Subject: RE: 3/2020/0309 - Spout Farm, Preston Road, Longridge, PR3 3B(30429)

Tim, I refer to the comments below and now enclosed revised information to address the points raised by the LLFA regards the surface water drainage system for the site.

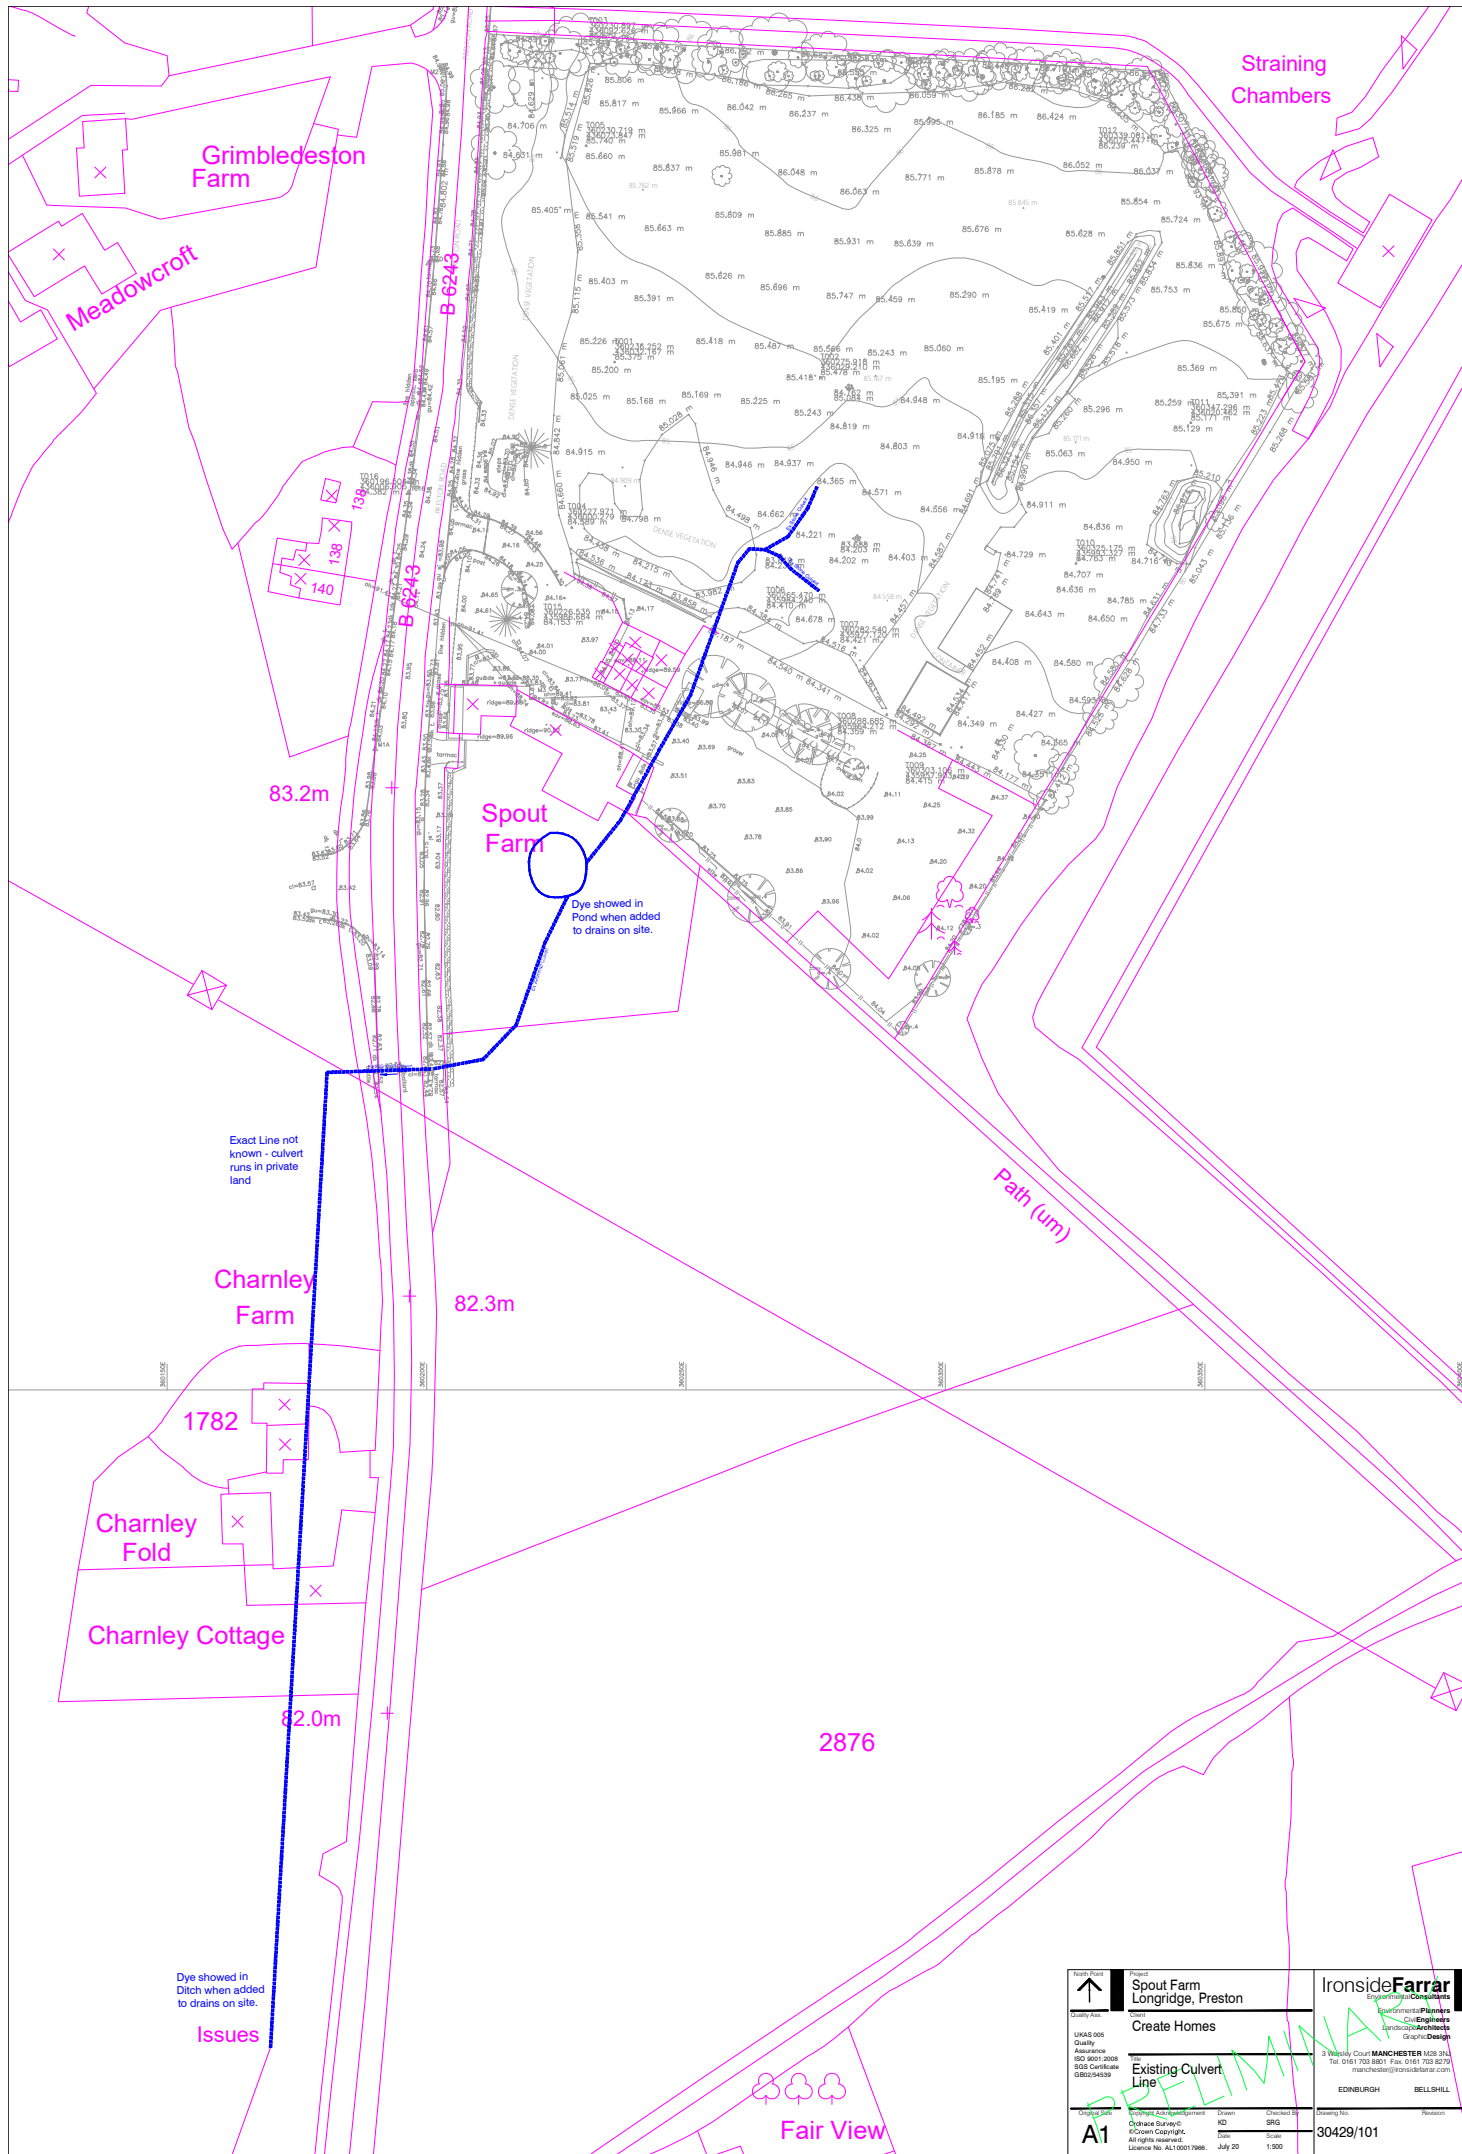
Lack of information regarding the 225mm diameter culvert referred to in section 6 of the applicant's FRA

The recollection is correct. Attached is a sketch plan from the site owner. He has previously confirmed the stone culverts have been located within the main site and drain dye added. The dye was noted in the pond that is still within the Spout Farm site but outwith the development area; from the pond the culvert continues to the road crossing where there is now a manhole just to the north of the new bus stop.

The dye was then noted to be within the open section of watercourse to the south of Charnley Fold; the exact route of the culvert, through or to the rear of Charnley Fold is not known but the watercourse definitely links to the open section that is now within the Kier development.

I have added the route provided on the sketch to the topo survey and the OS base plan of the area – drawing no. 30429/101.
